Project Name: CLAYTON HEIGHTS

DEVELOPMENT REVIEW BOARD – SPEED MEMO

DRB CASE NO/PROJECT NO: 1006955

Item# 11
Project# 1006955
Hearing Date: Dec. 5, 2007

**PLAT OF  
 LOT 4-A  
 BLOCK 14  
 CLAYTON HEIGHTS SUBDIVISION**

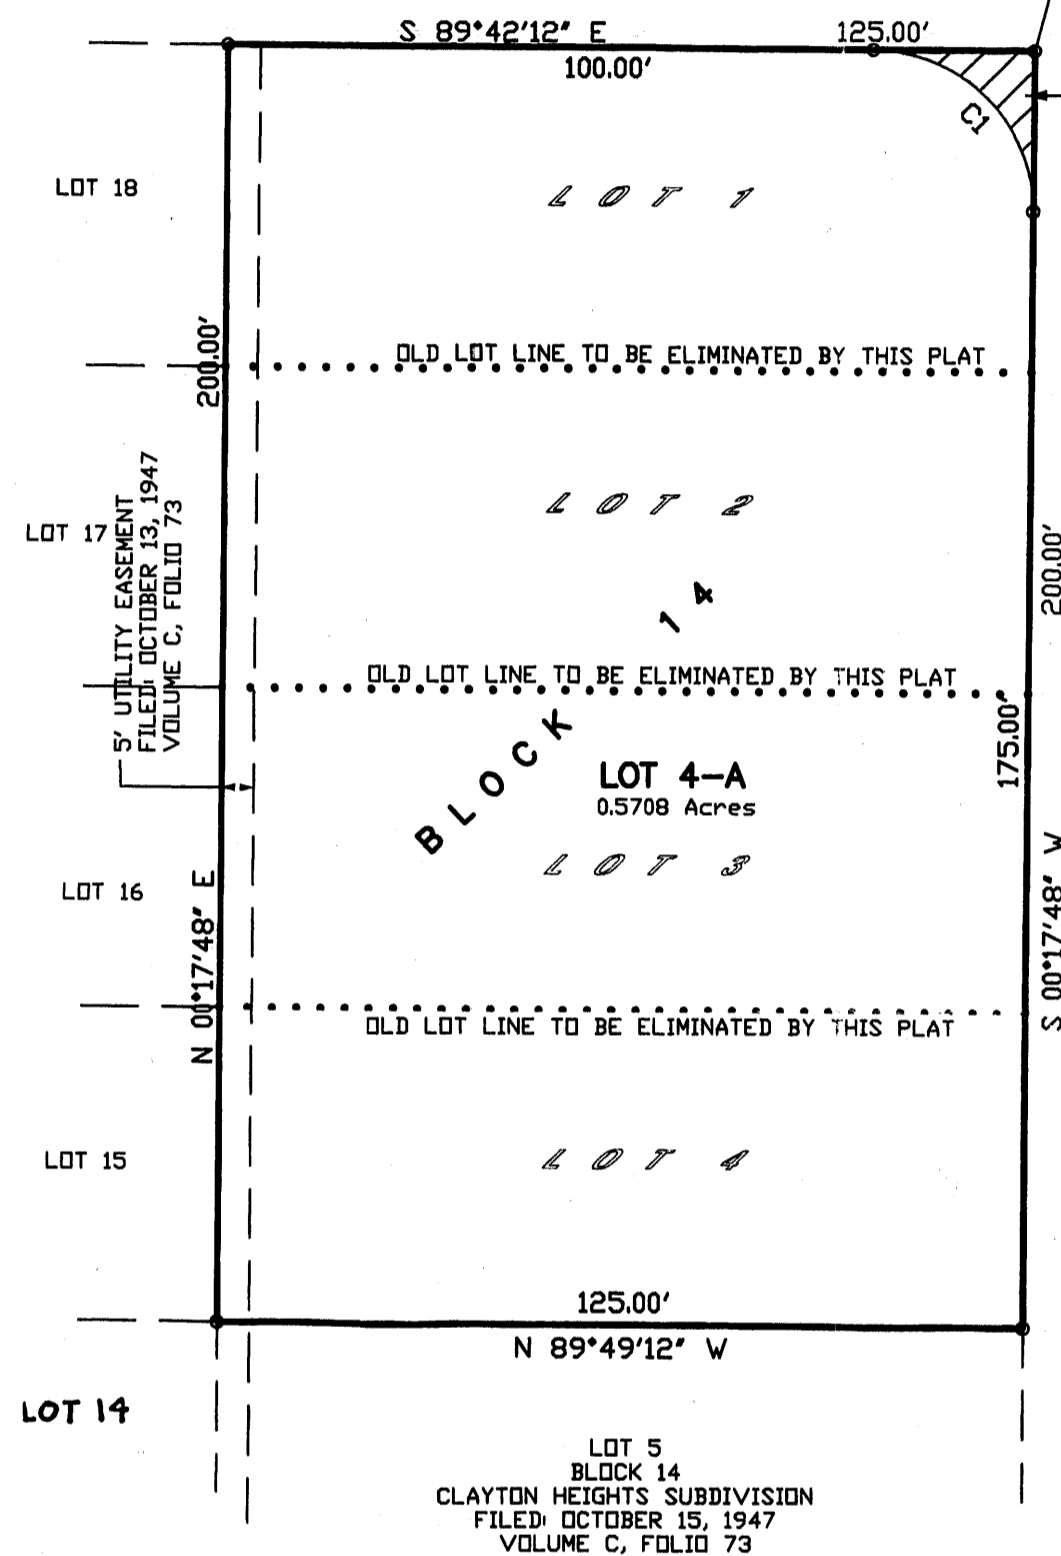
Provide an exhibit for Ross Avenue and Wilmore Drive showing the location of sidewalk and defining the distance from face of curb to the property line
